16 May, 2014

Your ref: MP10_0046 Mod 2

**Environmental Assessment
Russell Vale Colliery – Underground
Modified Preliminary Project (MP 10_0046 Mod 2)**

Title
RUSSELL VALE COLLIERY
WONGAWILLI SEAM GEOLOGY PLAN
AREA: MG6 (CORRIMAL FAULT)

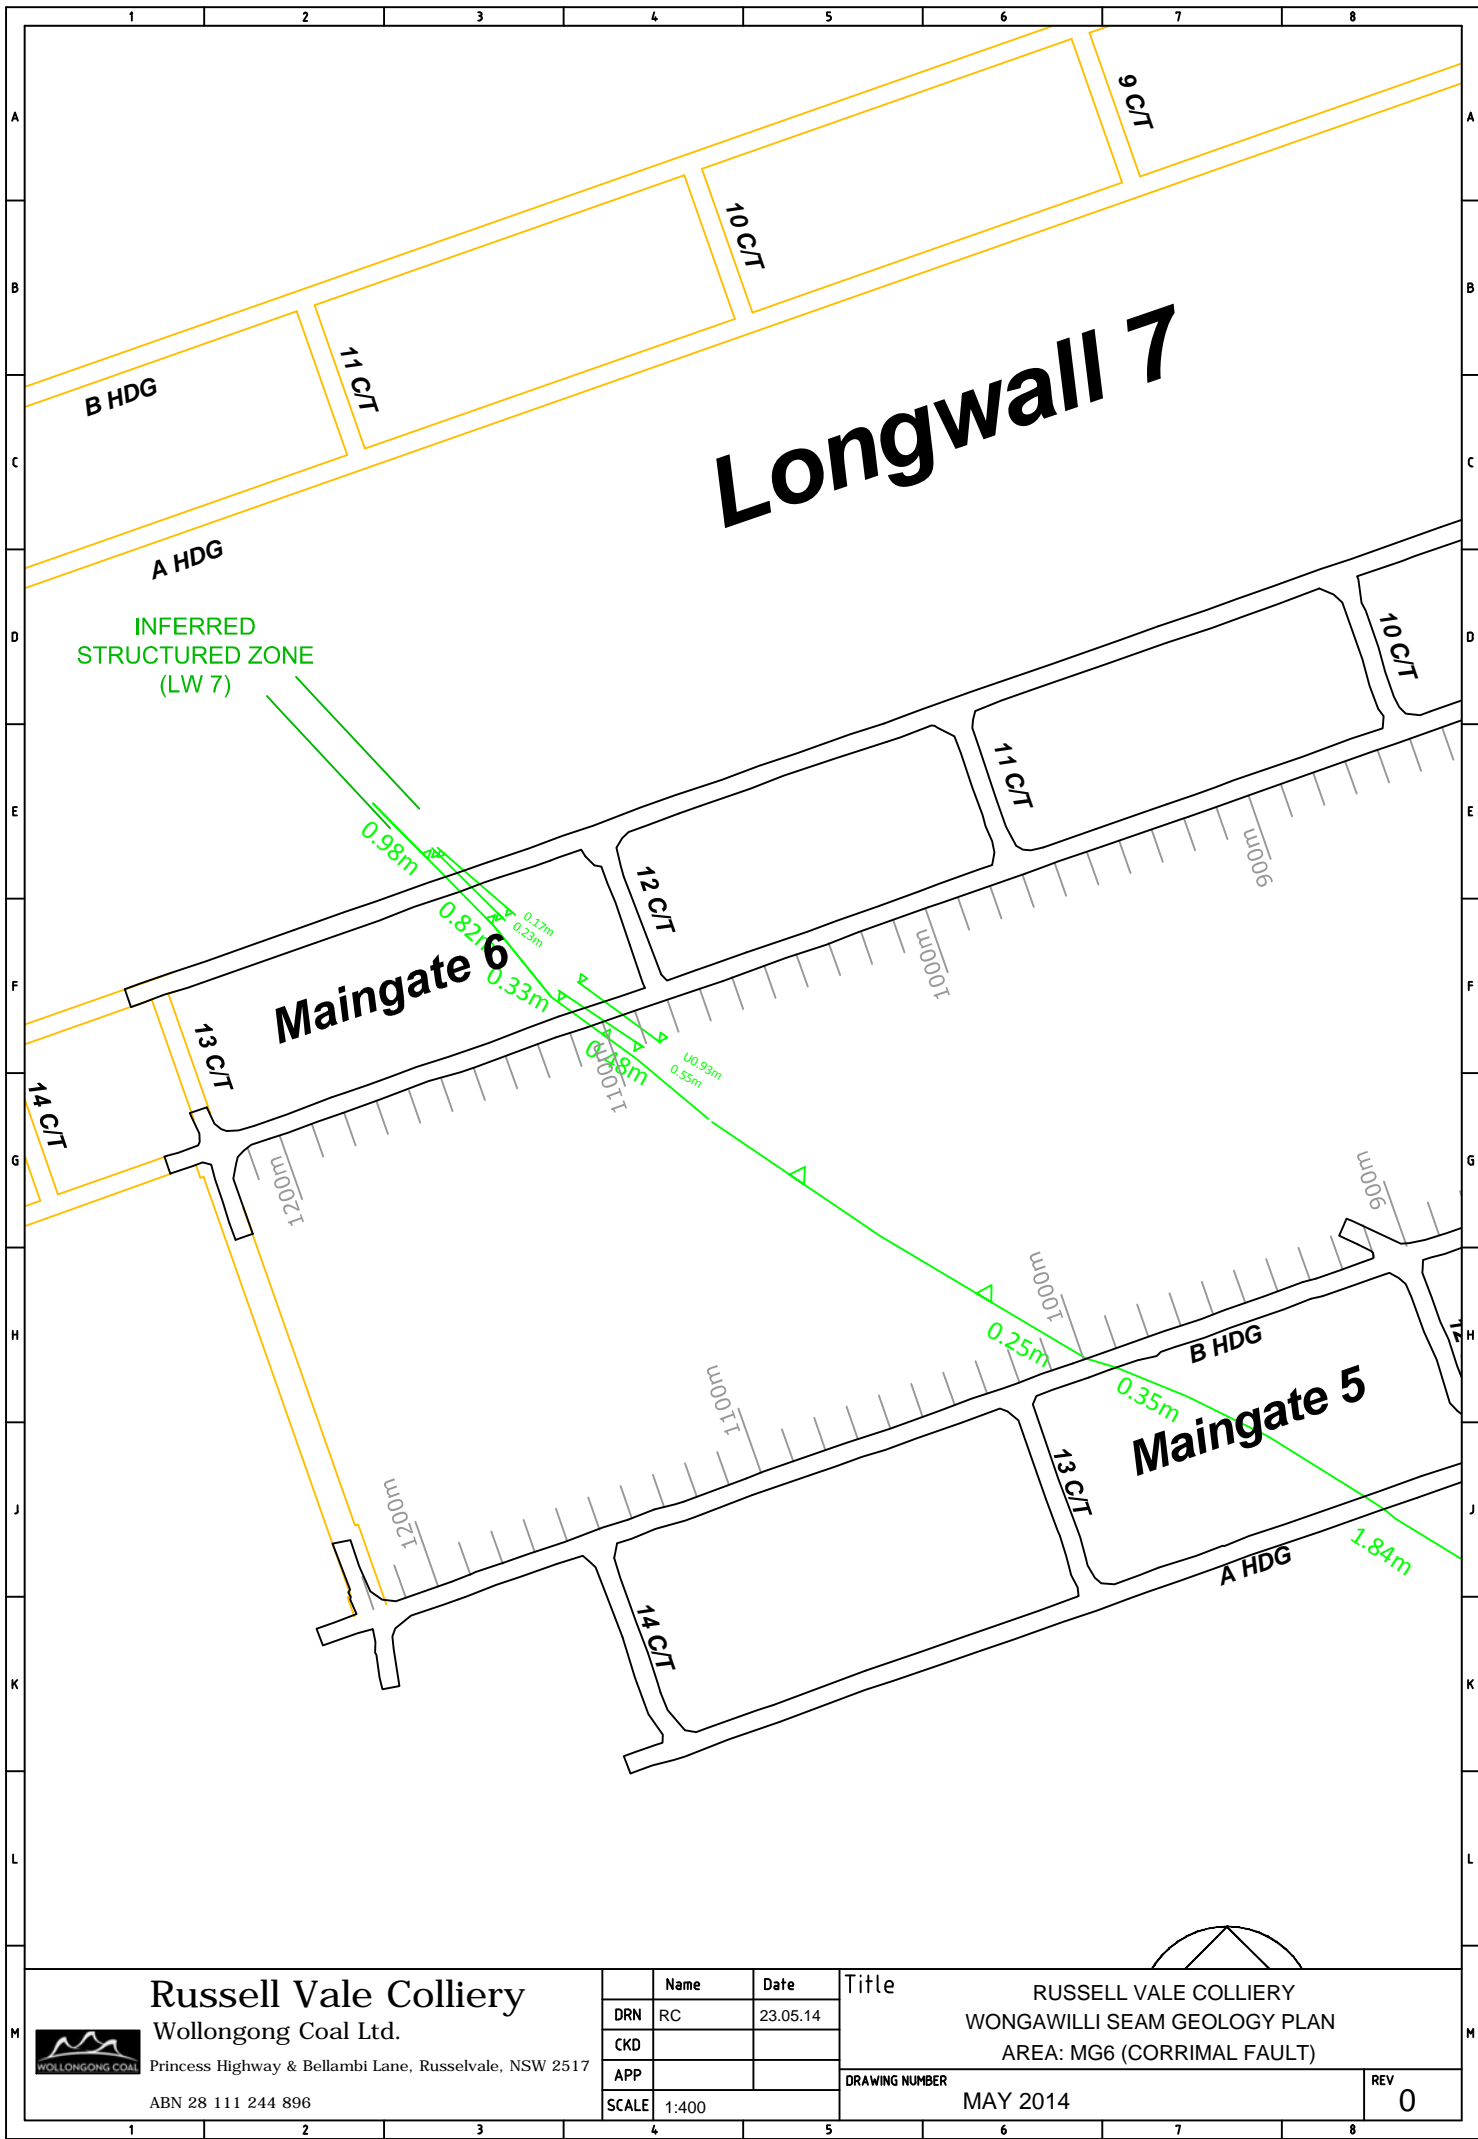
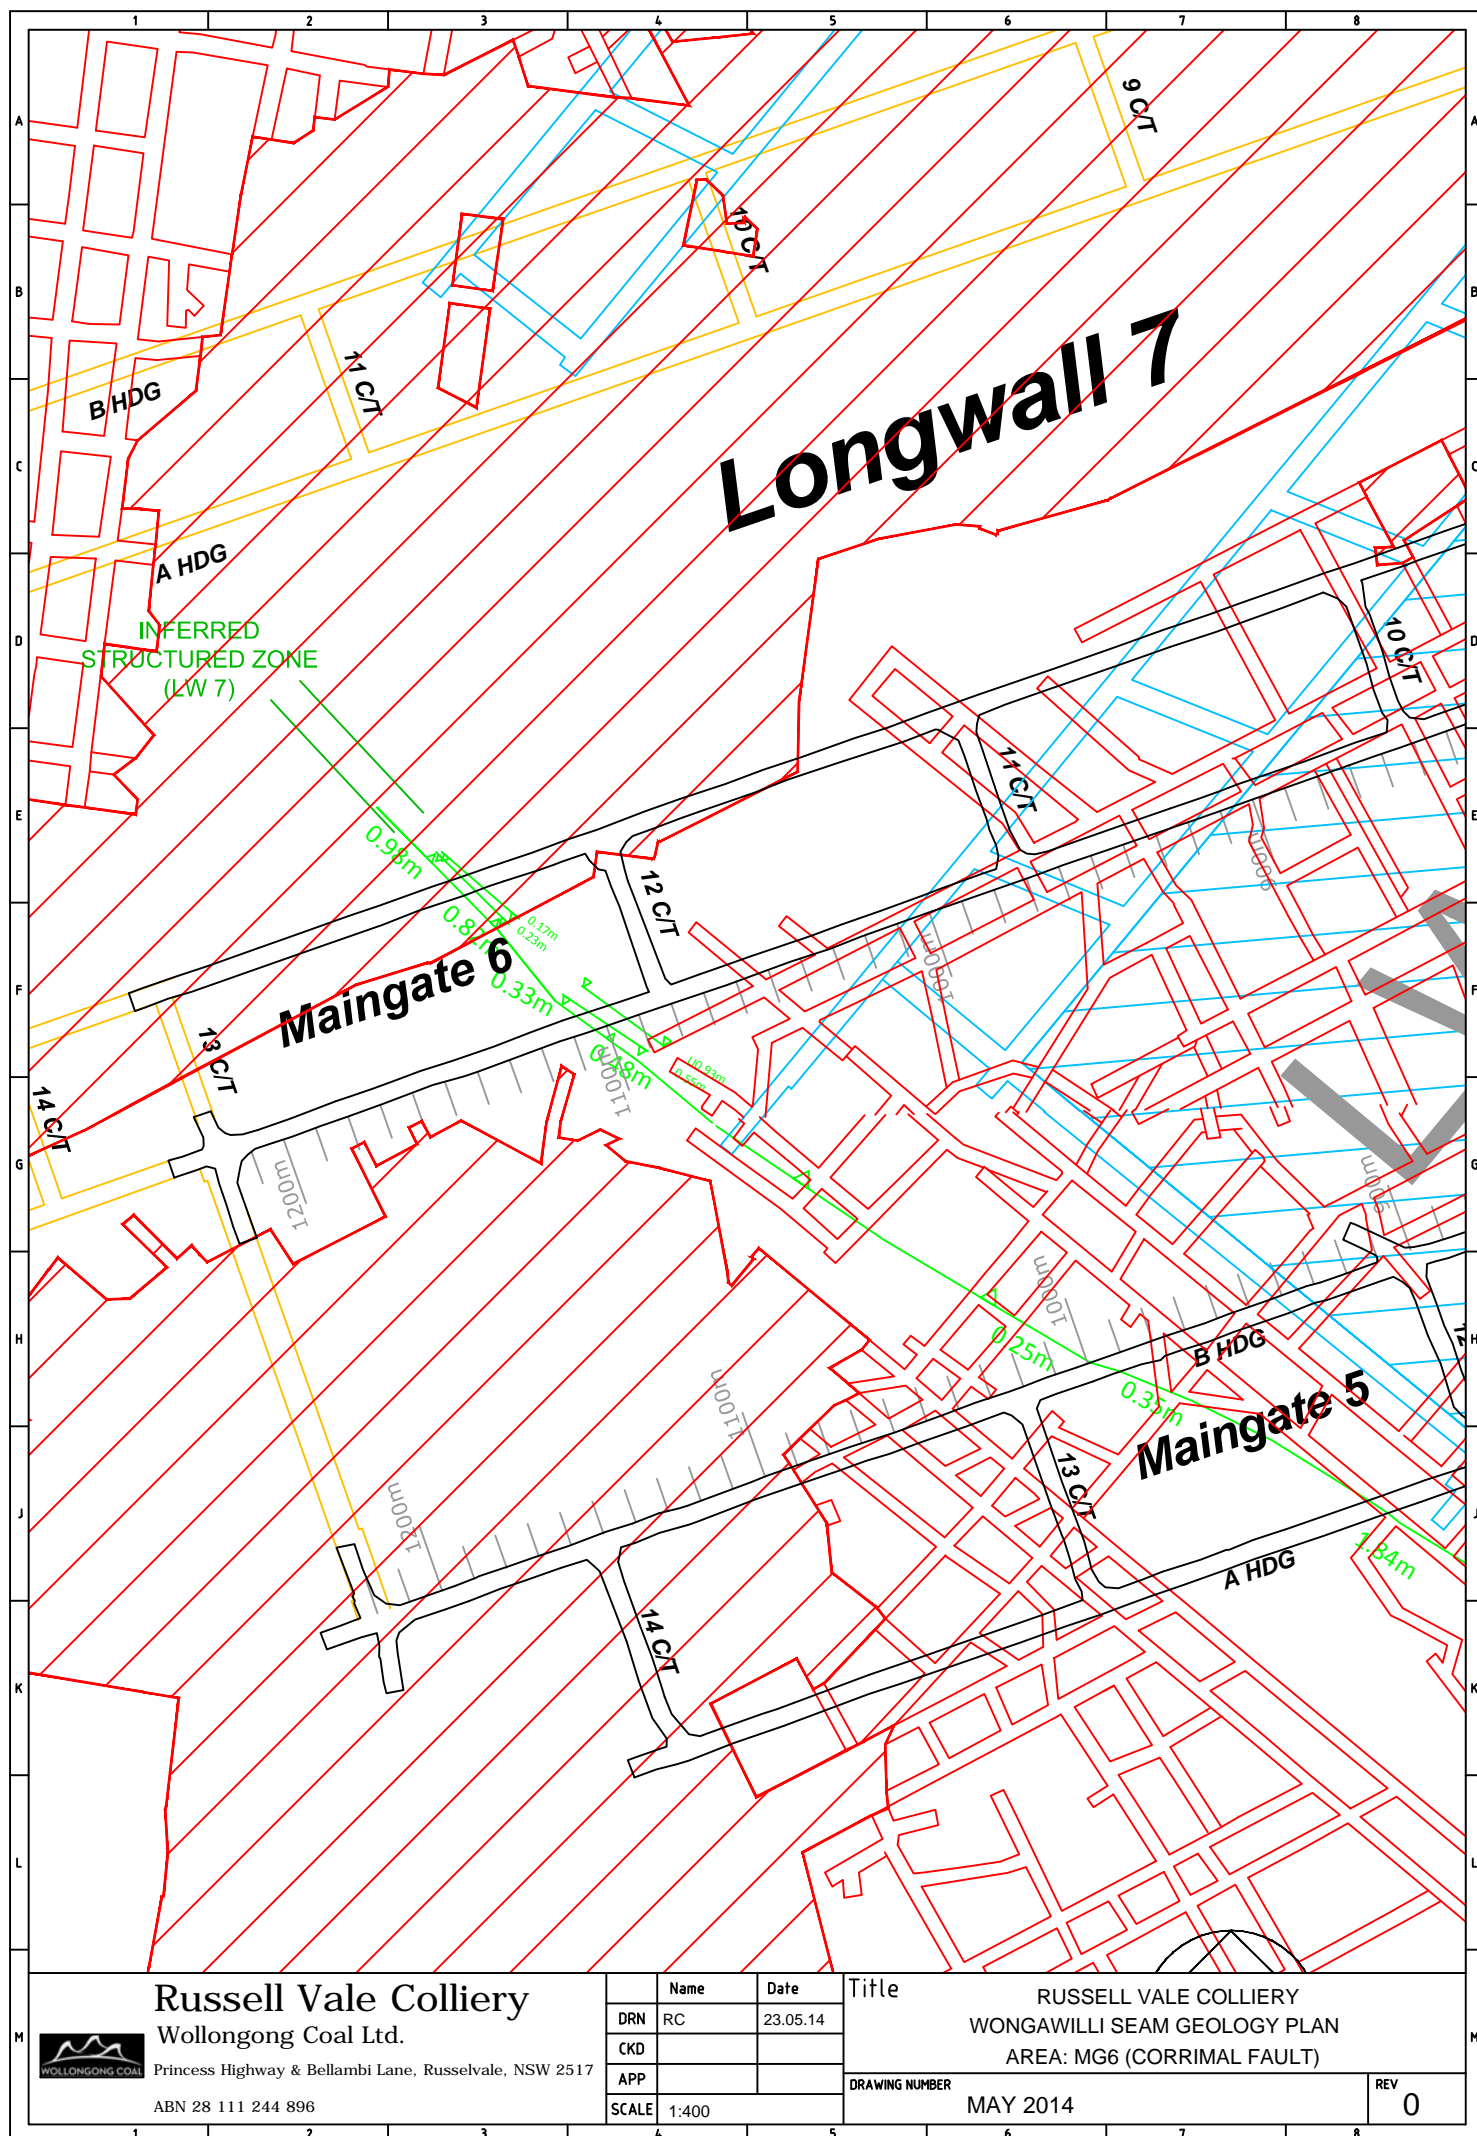
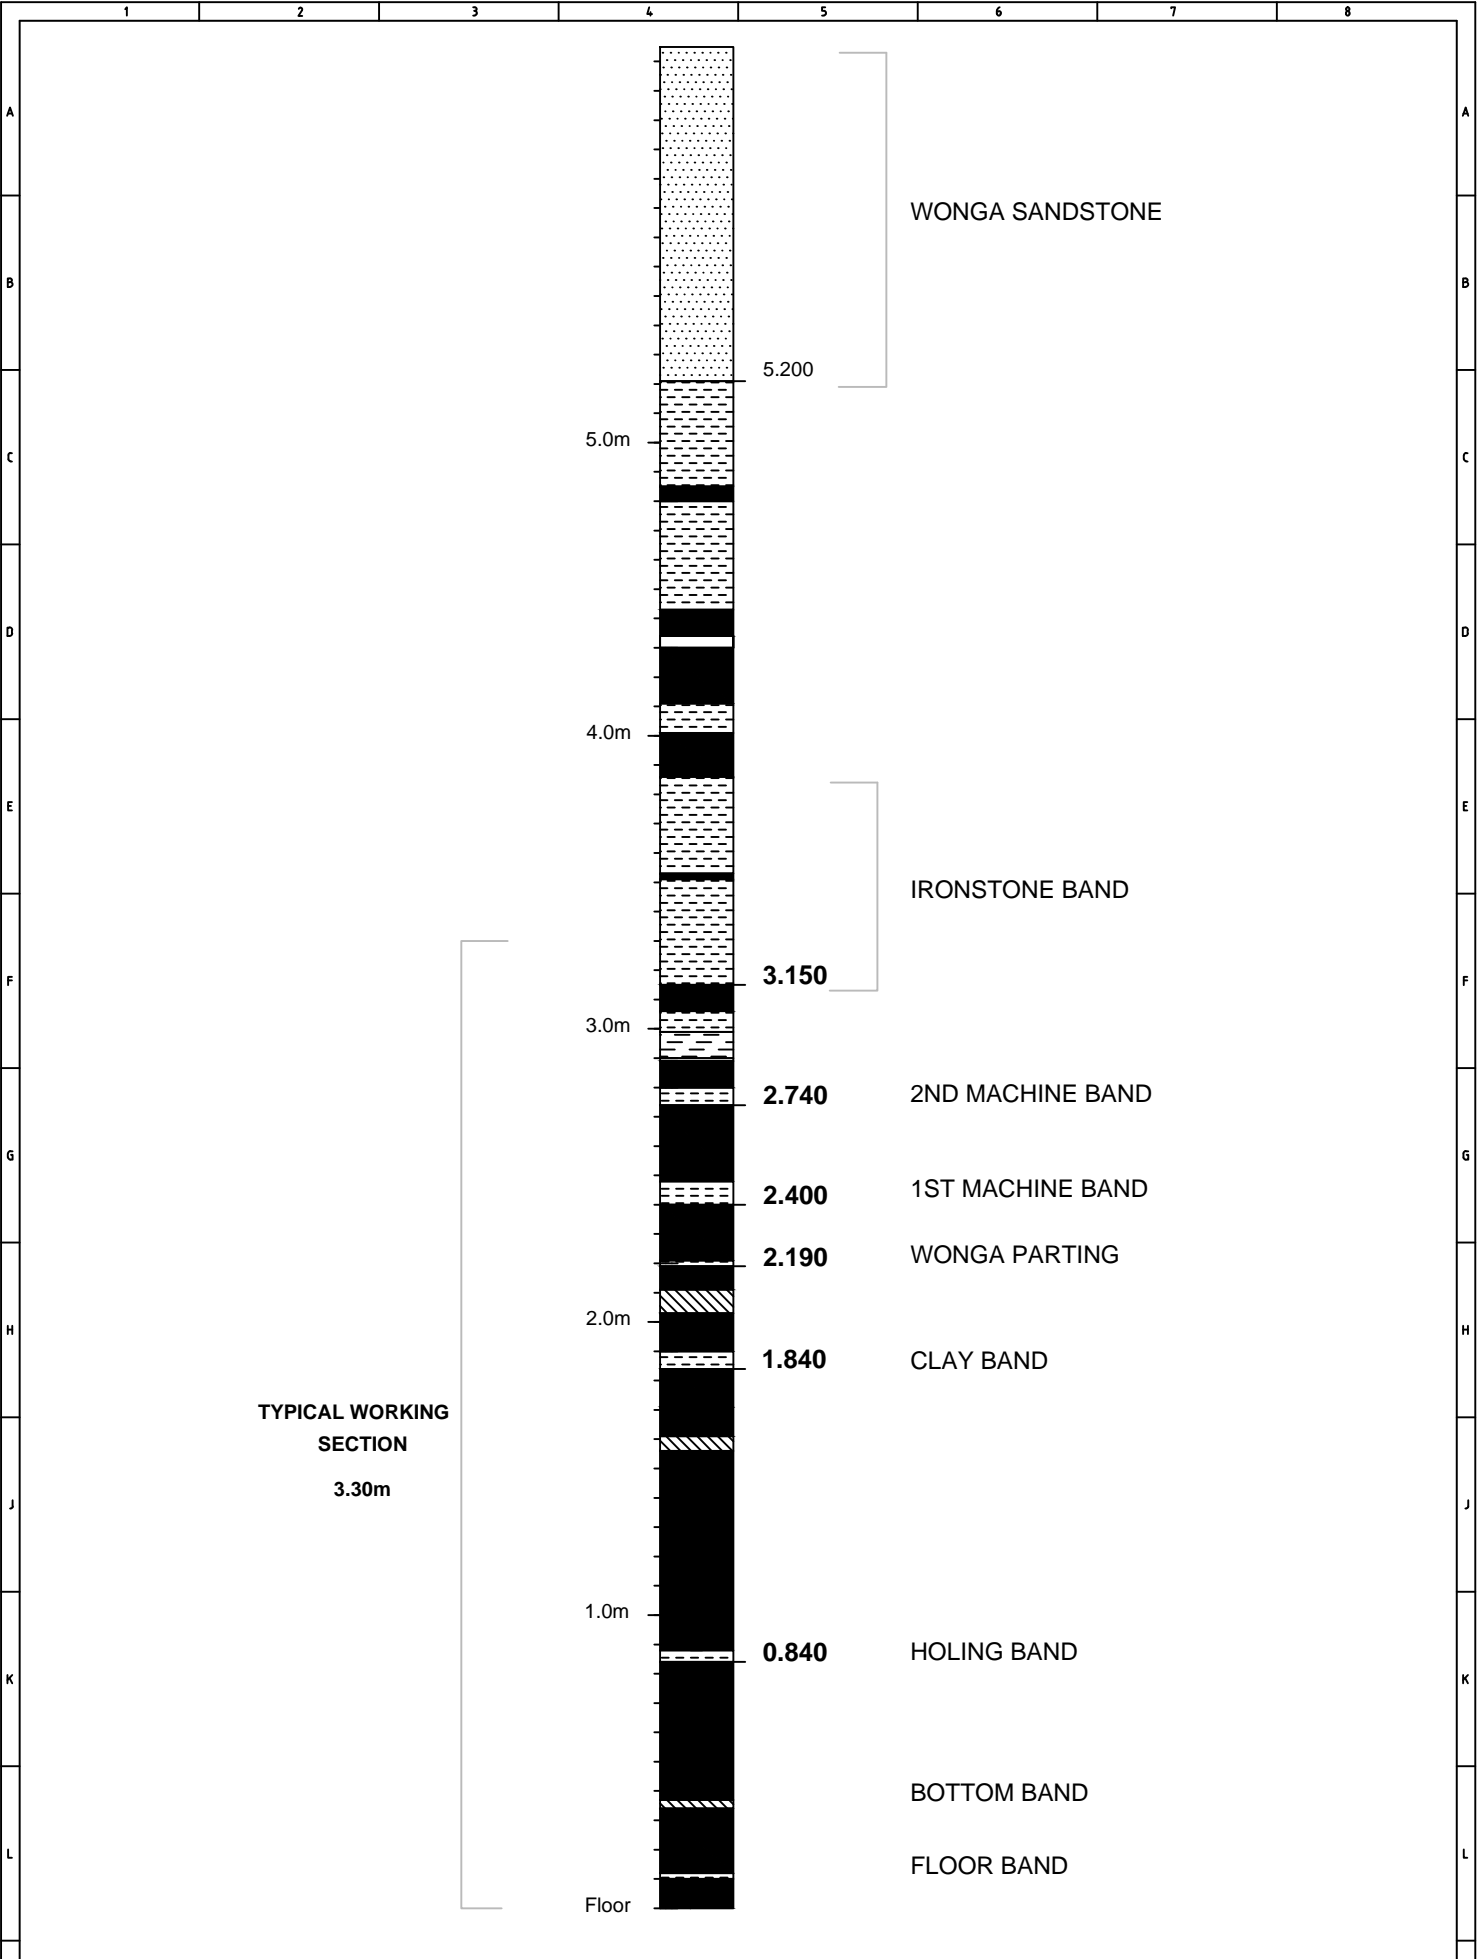
Longwall 6 maingate and tailgate roadways have both intersected the Corrimal Fault with throws of over 1m. The fault is present in the area to be extracted by the first 400m of LW6.

The proposed first 400m of LW6 extracts through the zone of the Corrimal Fault. In TG6 the development intersected 3 faults (between 12c/t and 13c/t) which had total throws of approximately 1.8m upthrown to the SW. In MG6, three faults have been intersected so far (development not completed). One is upthrown by 0.93m another downthrown by 0.55m and the third is upthrown by 0.48m.

A borehole between LW6 and the Reservoir that investigates/monitors the Bulgo Sandstone needs to be in place before LW6 extraction commences.
